**KIRKLEES METROPOLITAN COUNCIL
INVESTMENT & REGENERATION SERVICE**

Reference No: 2017/62/94039/W

Site Address: 14, Howard Avenue, Lindley, Huddersfield, HD3 3DJ

Description: Erection of two storey side, single storey rear extensions and dormer to side

DRG NO 1740 .5 SCALE 1:50

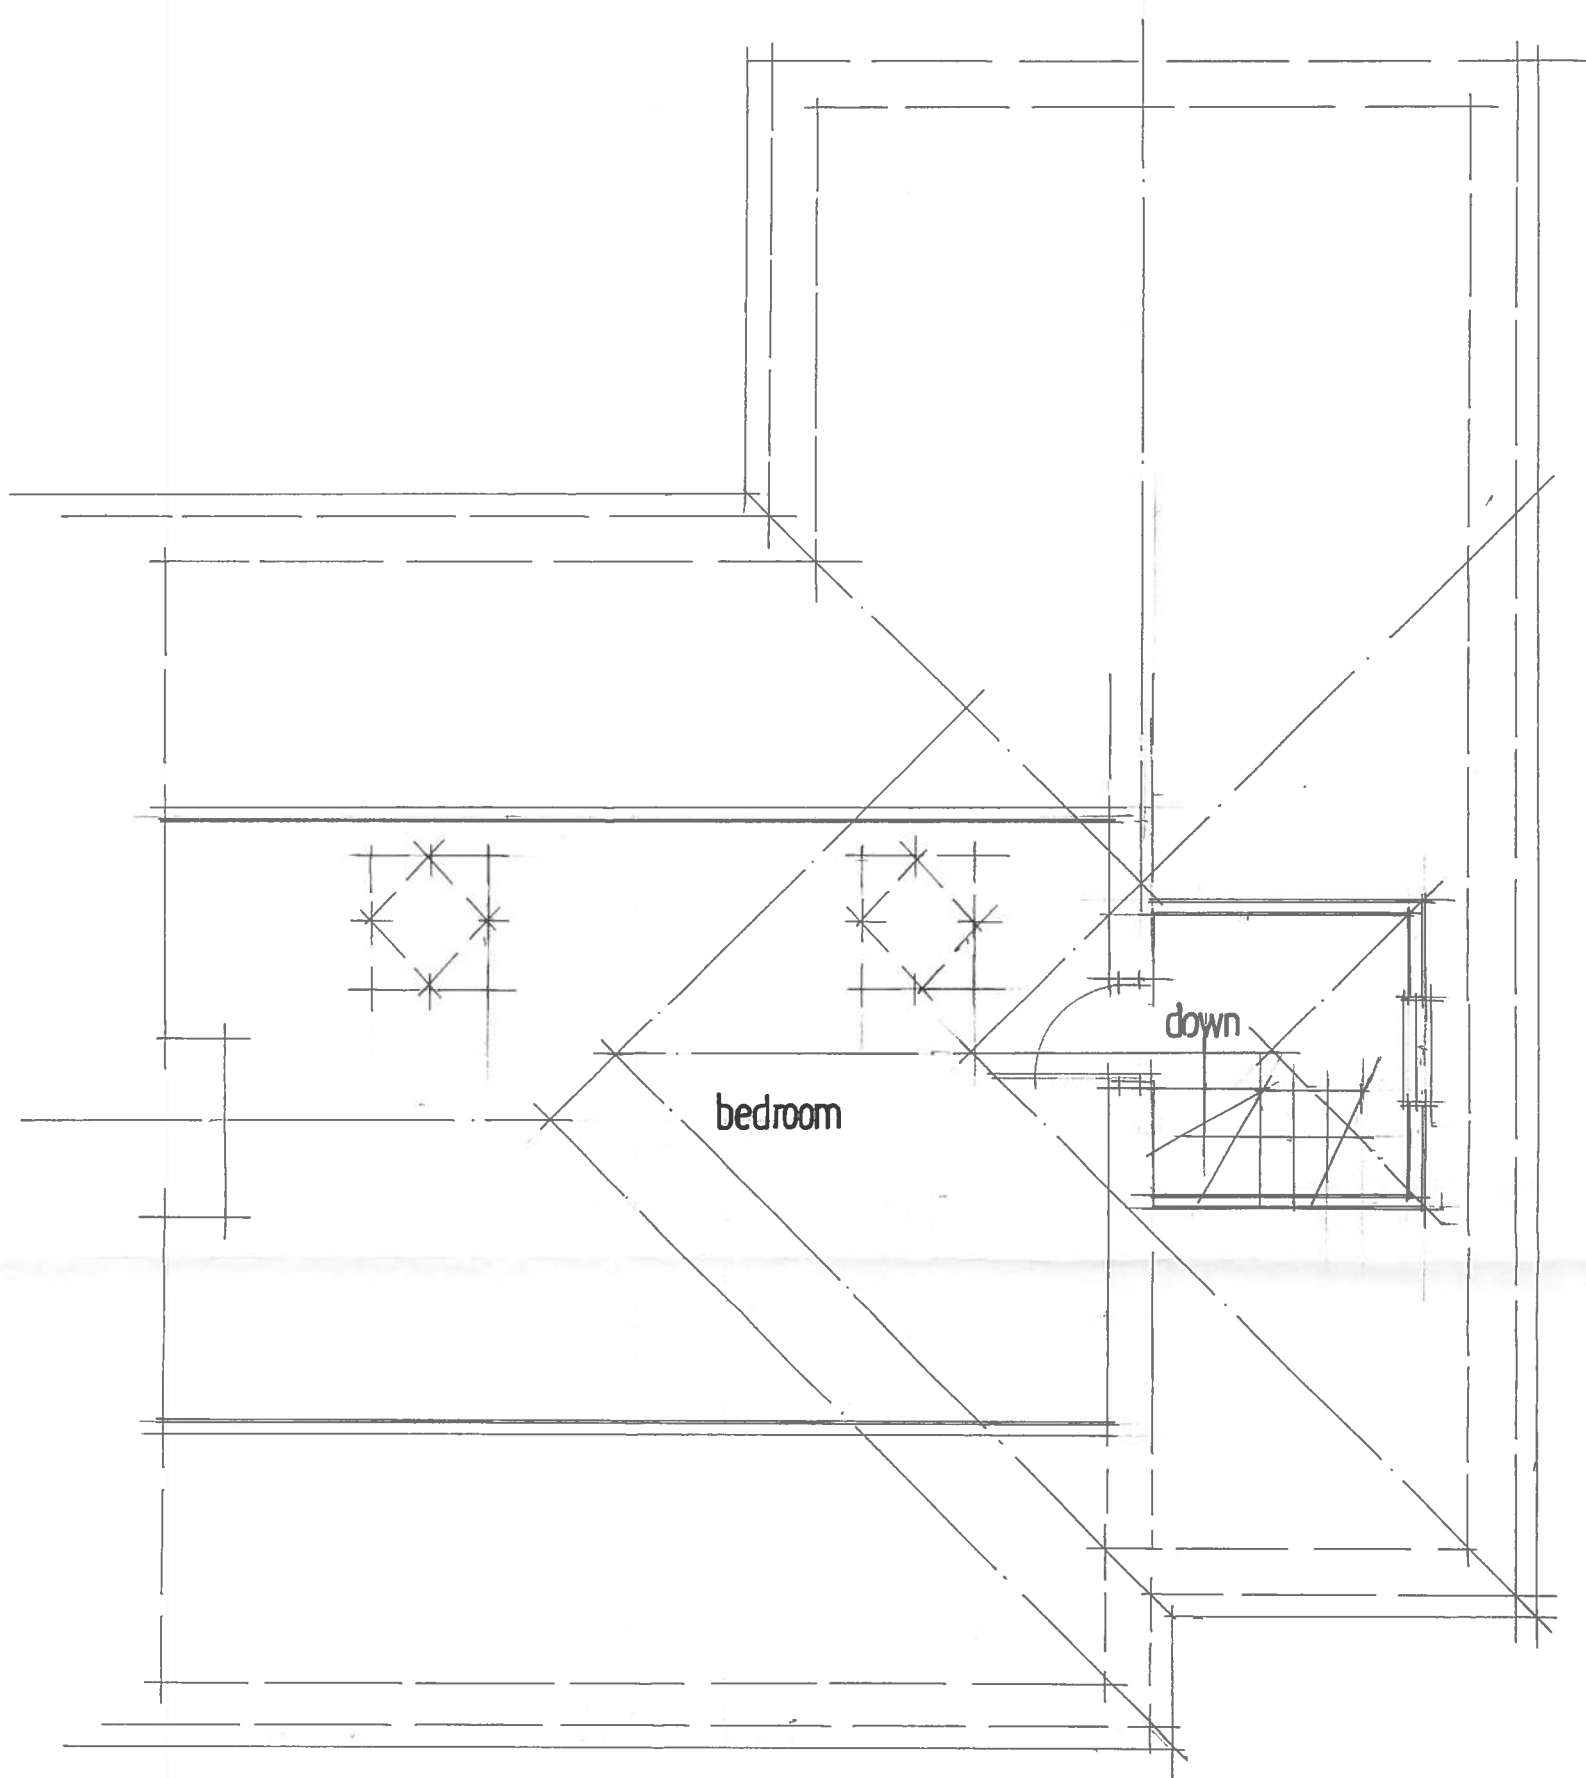
The proposed dormer would be within the new roof space for the side extension located on the side elevation. The dormer would be 1.8m by 2m with a small hipped roof, with the ridge running through from the extension roof, providing a new staircase to the loft conversion. Two new roof lights would be created on the rear roof slope.

DRG NO 1740-8B SCALE 1:50

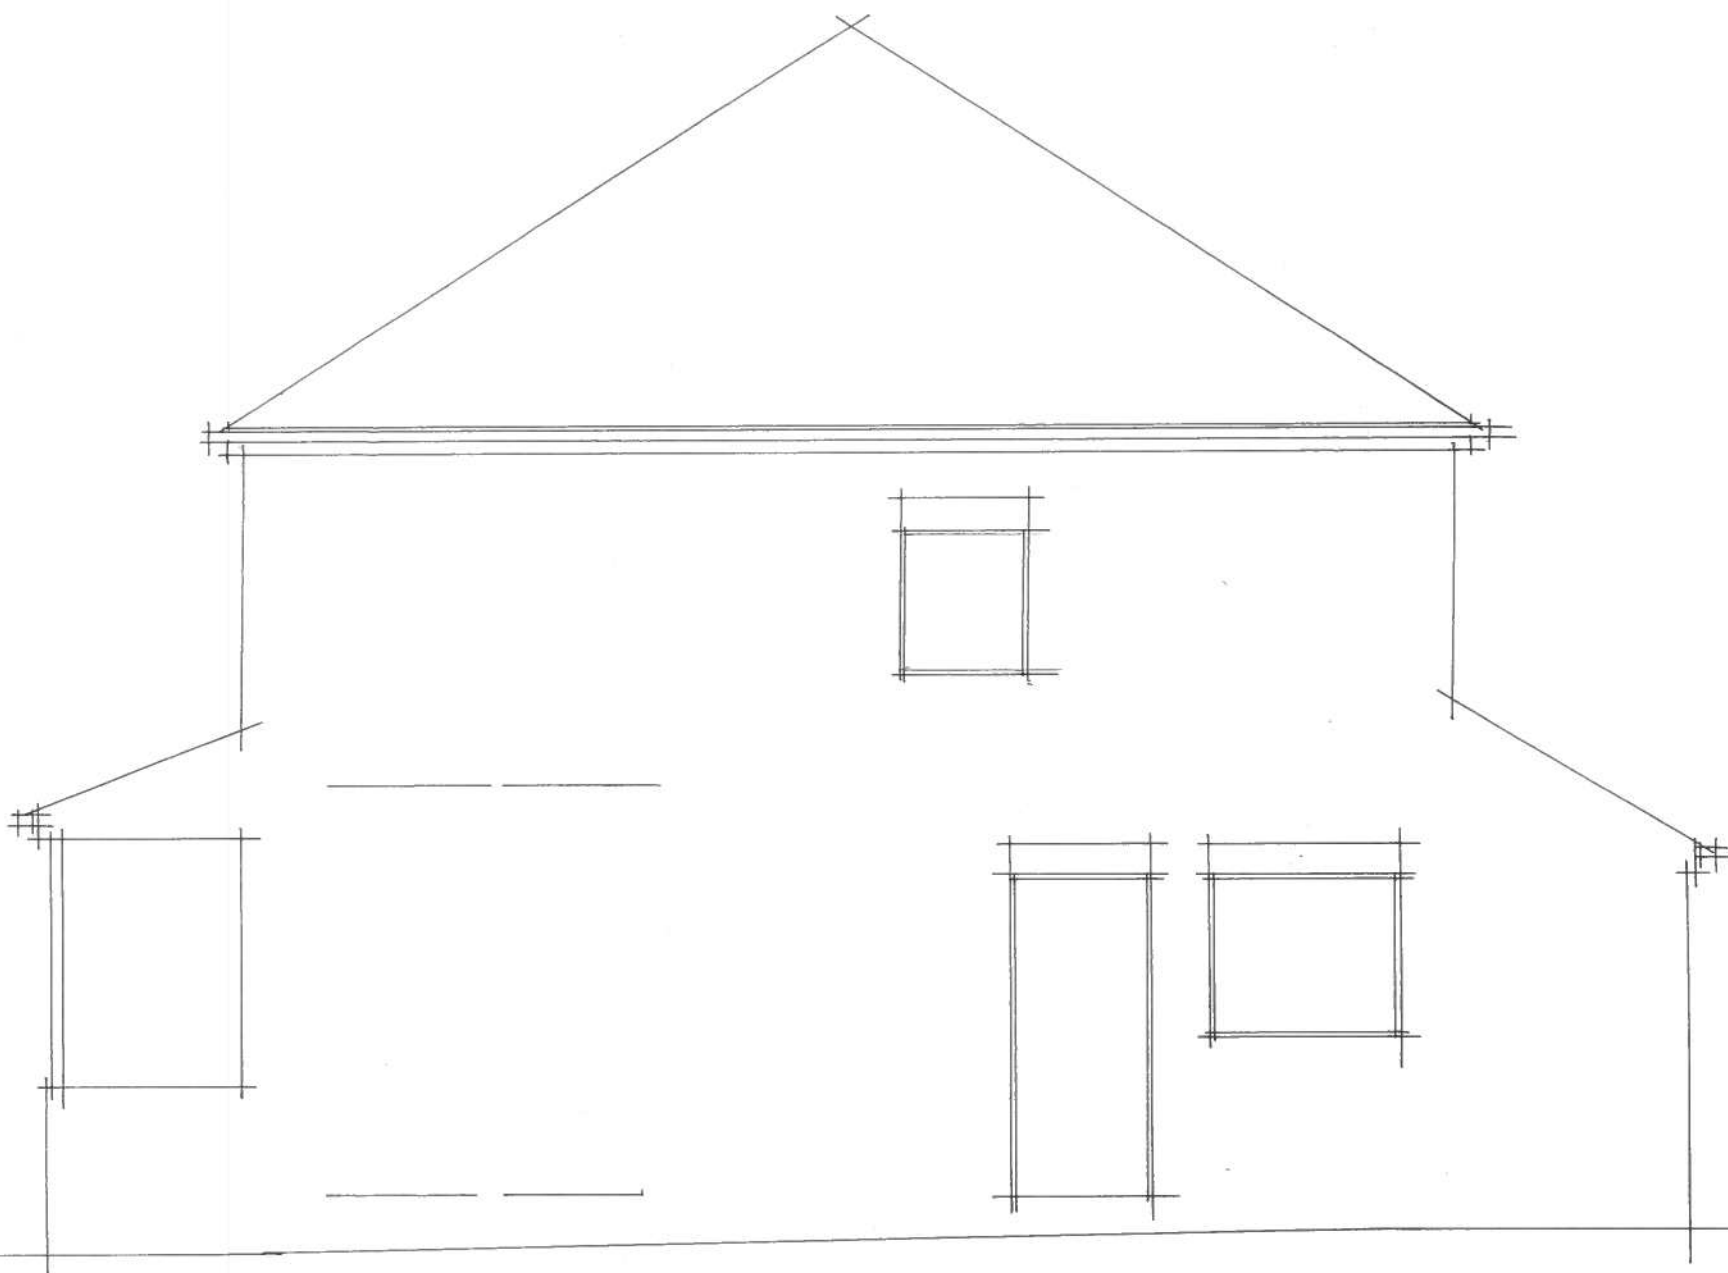
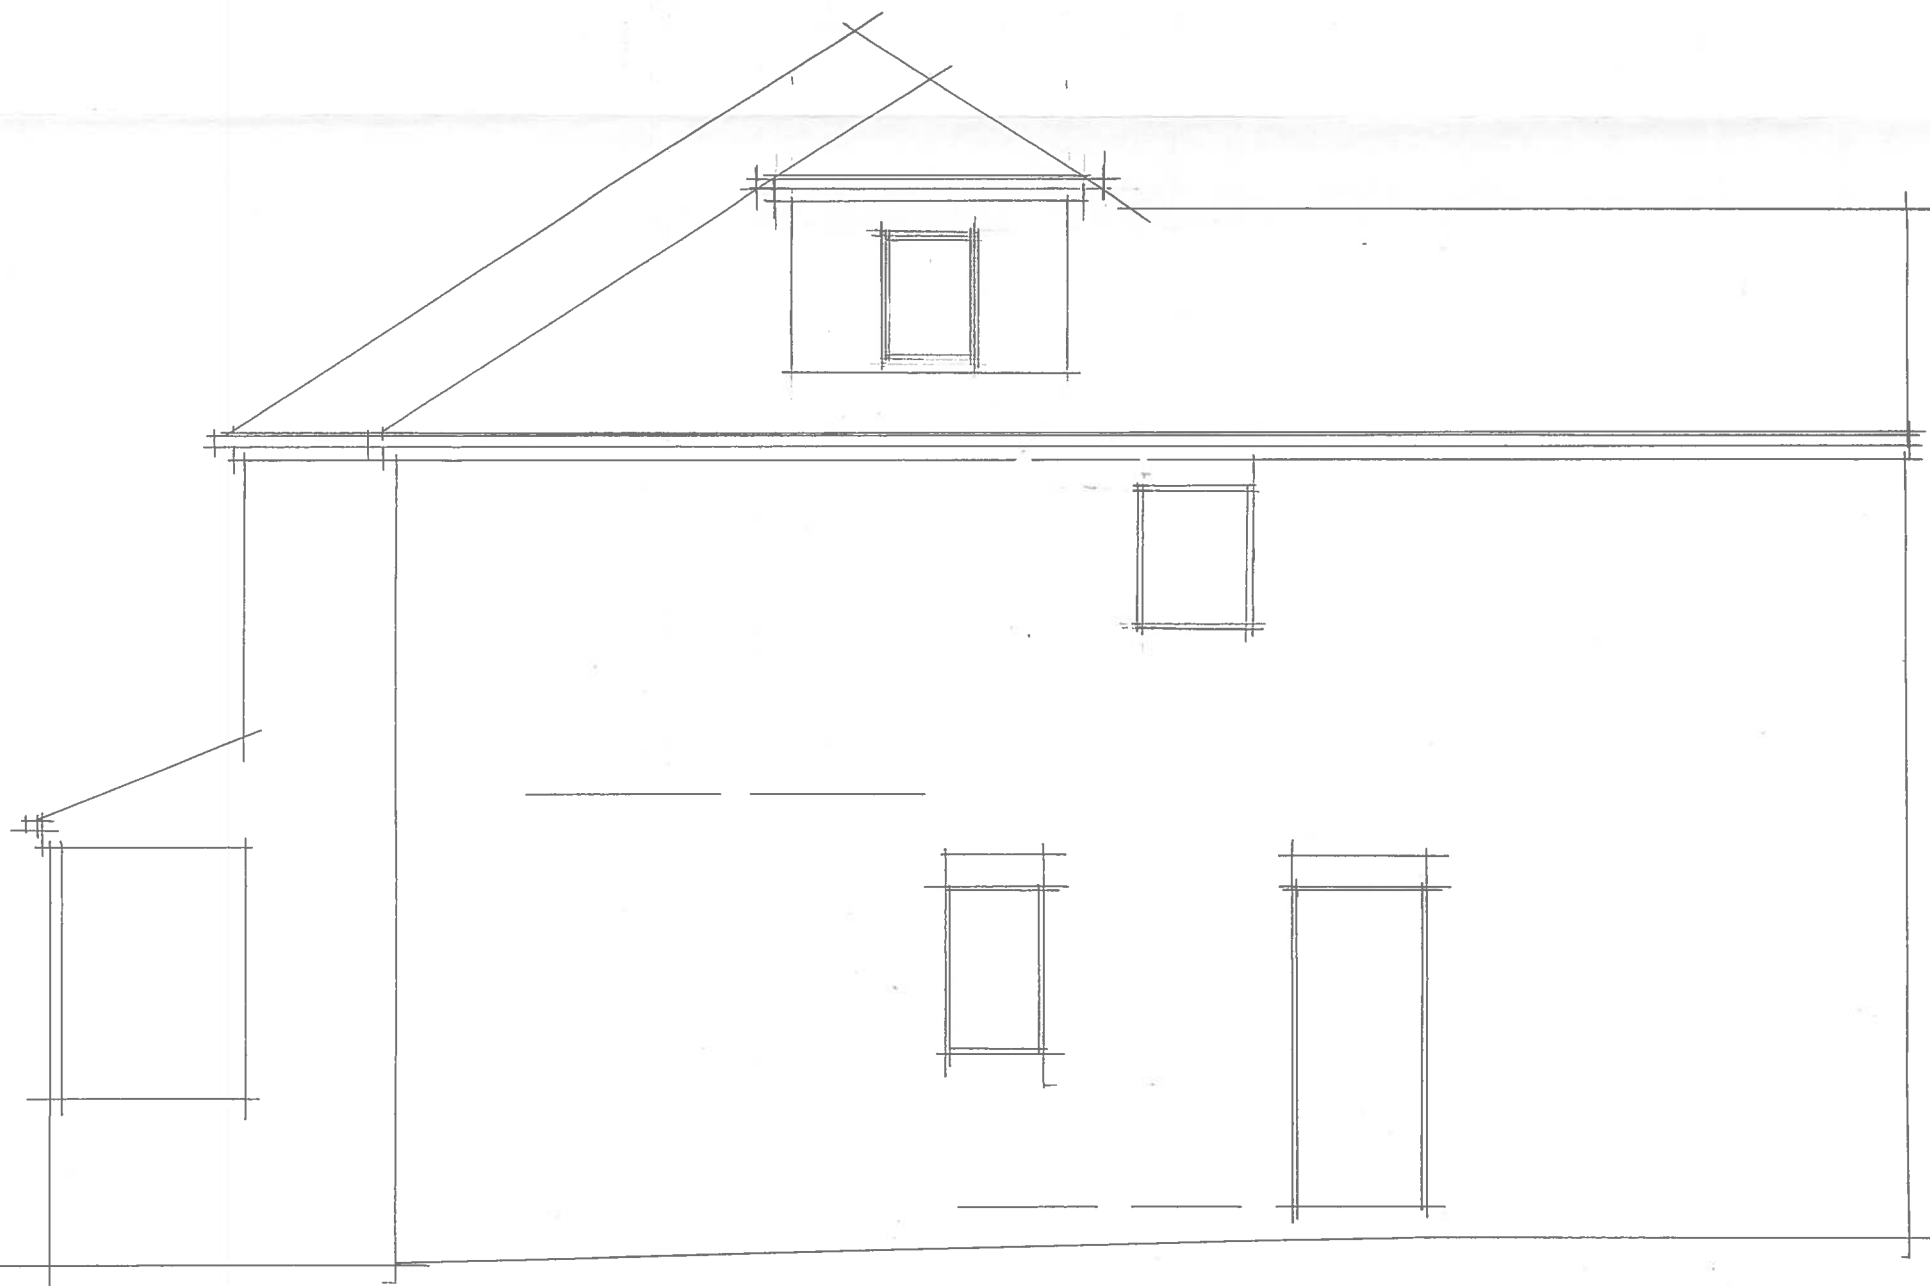
Finally the proposal includes a side dormer within the hipped roof of the side extension. The previous application incorporated a new gable to the side extension which was deleted through negotiations with the agent.

The concerns raised previously still stand for the design of the dormer window now proposed. Whilst the current dormer is smaller in scale than the scheme previously proposed and amended under application 2017/92609 the scheme of the current proposal would still carry the ridge of the extension through over the dormer, the dormer would be set in from the gutter by 0.5m, however would still introduce a vertical form to the front of the building which is considered to represent an incongruous feature within the street scene and the character of the wider local.

Such a feature is considered to be detrimental to visual amenity and would be contrary to policies D2, BE1 & BE2 of the Kirklees UDP, emerging policy PLP24 of the PDLP. Paragraph 64 in Chapter 7 of the NPPF advises that permission should be refused for development of poor design that fails to take the opportunities available for improving the character and quality of an area and it is considered that this would be the case for the proposed dormer window.

1. The proposed dormer, by reason of its design and location, would appear incongruous in relation to the host building, the street scene and would be detrimental to the visual amenities of the area and would therefore be contrary to Policies BE1 (i) & (ii), BE2 (i) and D2 (vi) & (vii) of the Kirklees Unitary Development Plan and Policy PLP24 (c) of the Kirklees Publication Draft Local Plan and advice in Chapter 7 of the National Planning Policy Framework.

DRG NO 1740-9

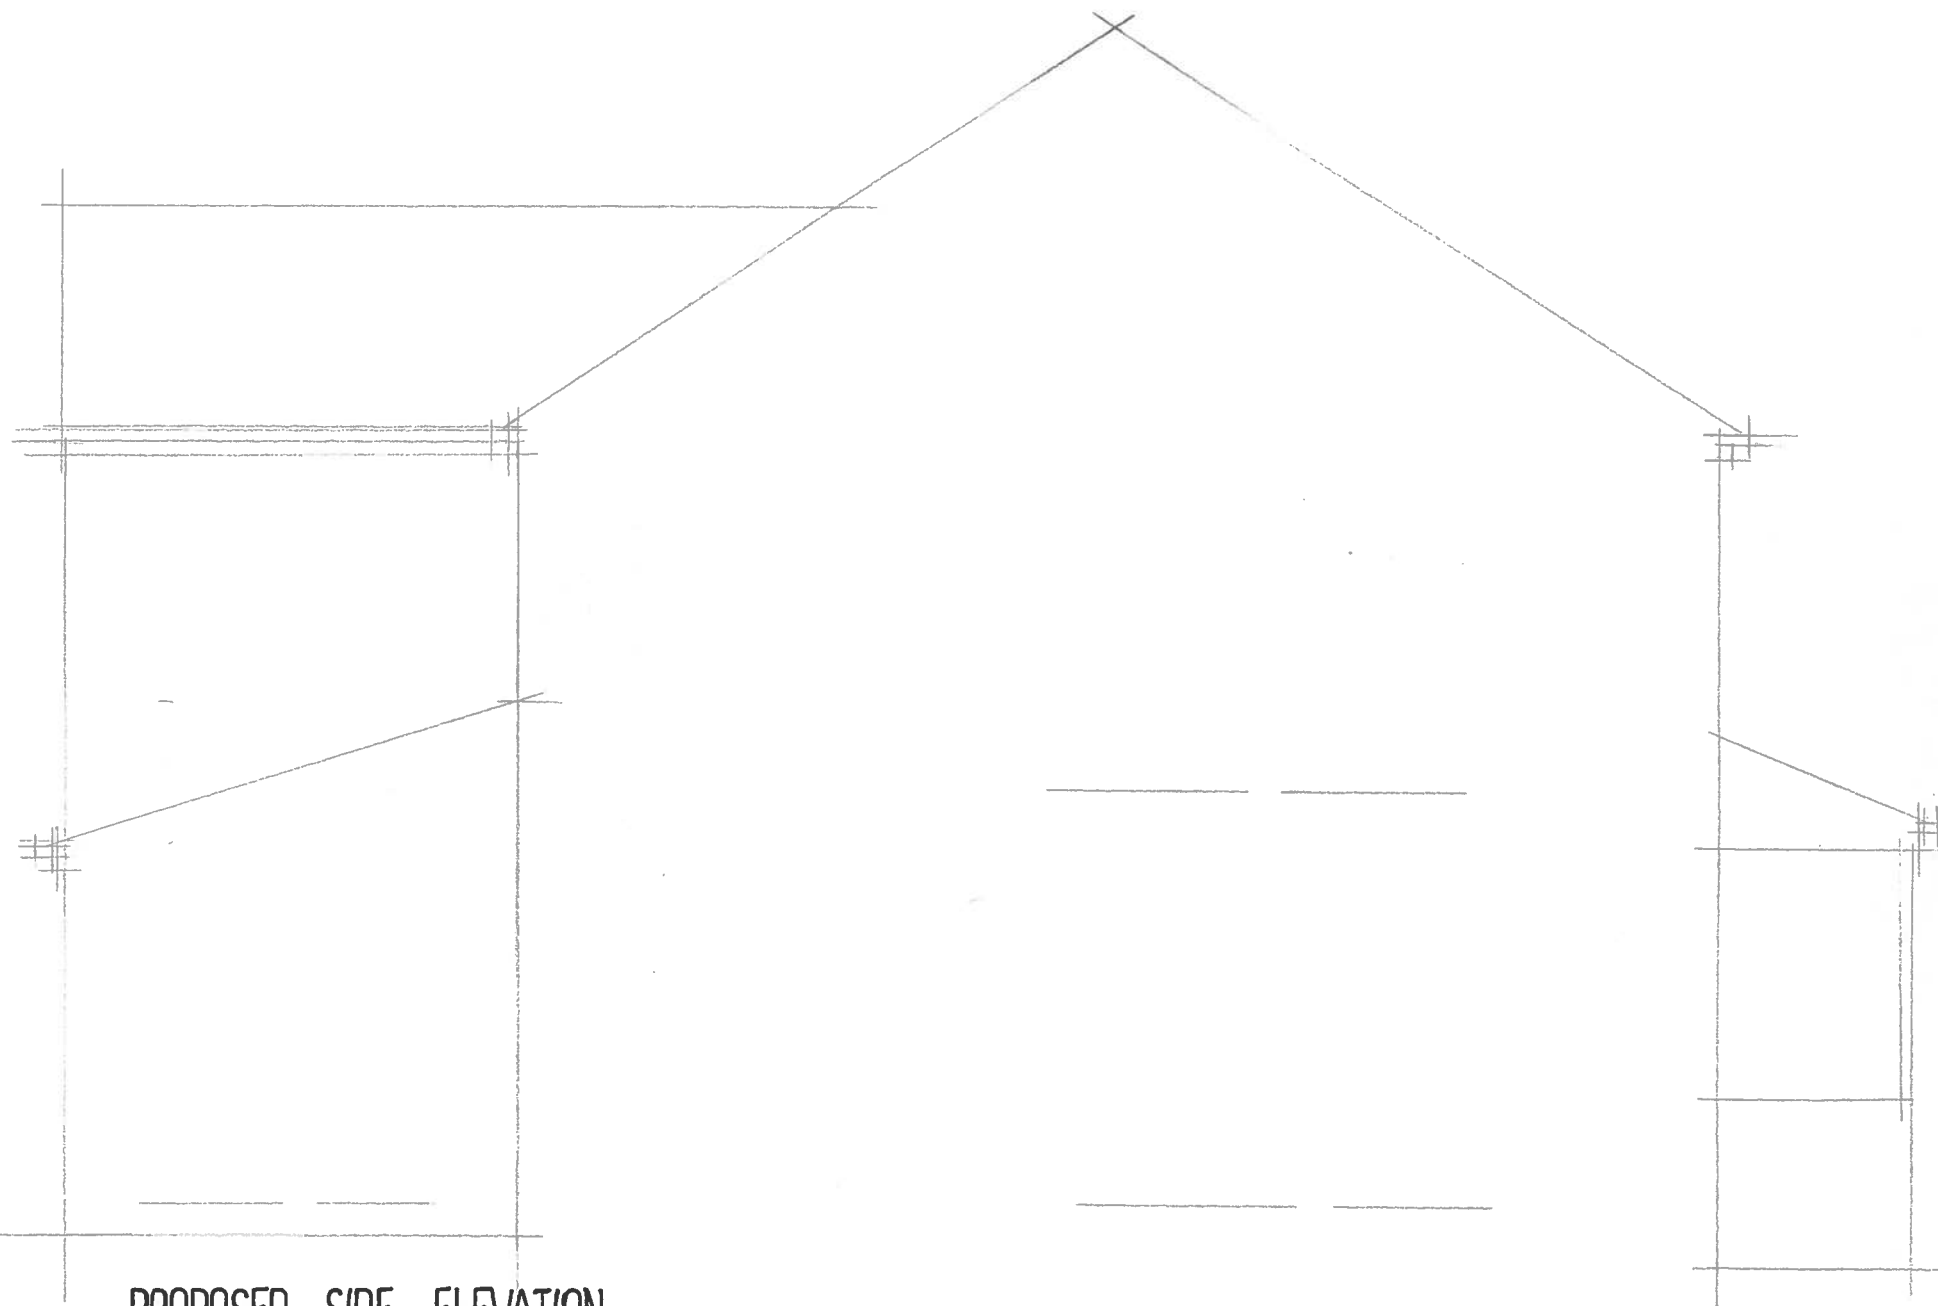
The proposed dormer window is to a landing within the staircase, therefore is not a habitable room window, however to overcome any concerns with regard potential overlooking, this could be conditioned to be obscurely glazed. Therefore there would be no overlooking issues from the dormer window.

With regard the extension already approved, there would be no overlooking as there are no windows in the side elevations of the 2 storey side extension apart from a bathroom window which will be obscurely glazed. This window

Response: The additional dormer window could be conditioned to be so.
